Alan Varela, Director

August 5, 2024

**Re: Sage Park at 6601 Sage Rd. SW  
Erosion and Sediment Control Plan  
Engineer's Stamp Date 7/10/24 (L10E030)**

REVISIONS	CITY OF ALBUQUERQUE
Draft 7/29/2025	CONSTRUCTION STORMWATER QUALITY STORMWATER SILT FENCE (SWSF)
	SHEET 1 OF 2

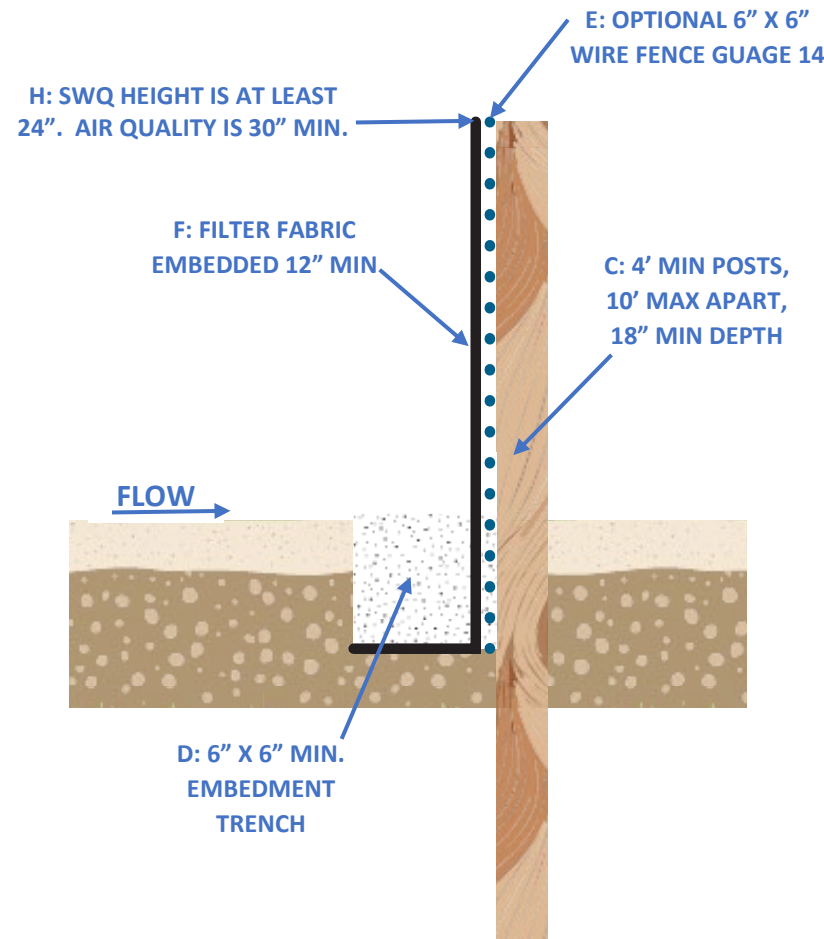
8. The Erosion and Sediment Control ESC Details on sheet 3 of 6 are missing the construction, inspection, and maintenance specifications required by the city's ESC Plan Checklist and CGP 9.6.1.c.i. Include construction specifications for the stormwater controls identified on the ESC Plan.

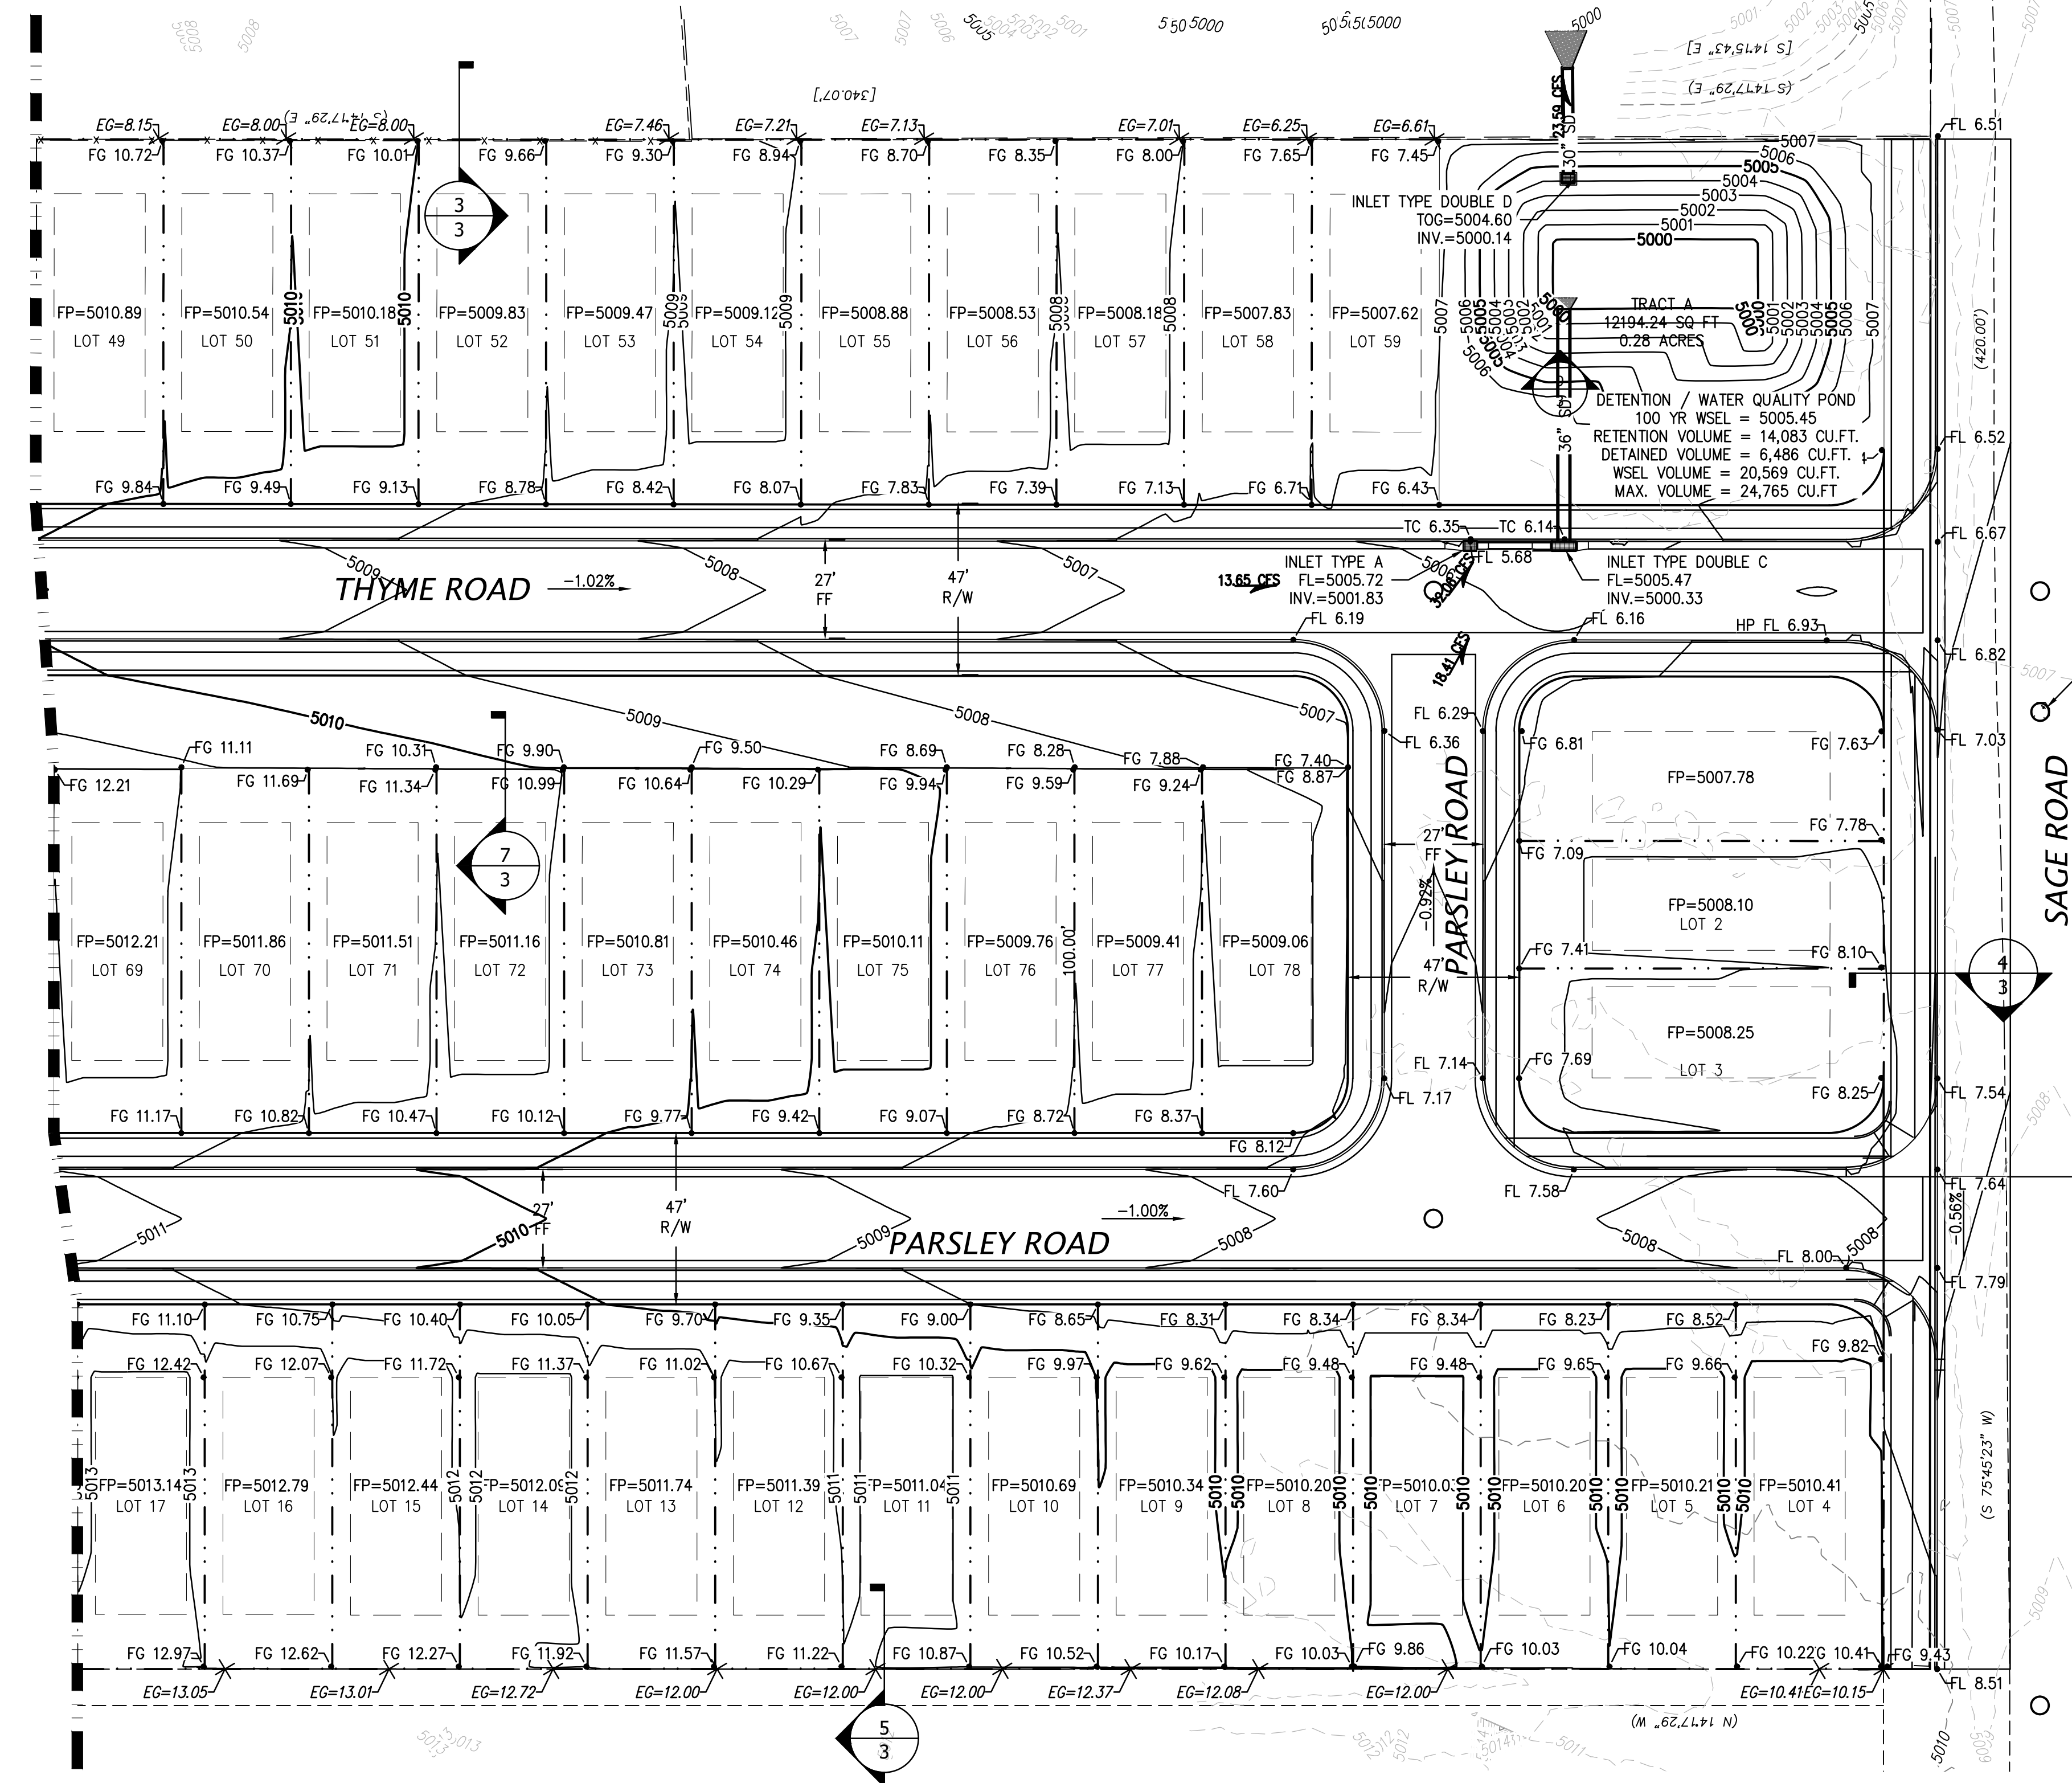
1. The ESC Plan must include design calculations and construction specifications for a temporary sediment basin per CGP 2.2.12 stamped by a Professional Engineer registered in the state of New Mexico since the area of land disturbing activities exceeds 5 acres. The permanent SWQ retention volume of 14,083 sf on the G&D Plan is only a fraction of the 36,000 cf temporary retention volume required by CGP 2.2.12.c.iii. The engineer must include design calculations, construction details, and specifications for a temporary sediment basin that will retain the design volume for the entire area draining to it, including offsite areas, whether disturbed or not. The design calculations and construction specifications must provide a safe, non-erosive outlet structure that will withdraw the excess 100-yr overflow from the surface of the retention pond per CGP 2.2.12.d. Conveyance stormwater berms and swales must be designed to collect the stormwater runoff from the area of land-disturbing activities into the temporary sediment basin and may be used to divert flows from upstream offsite undisturbed areas around the site. The construction exit shouldn't be located in the low corner of the site. Relocate it to the west access point and provide a diversion berm/swale along the south edge of the limits of disturbance for this project.
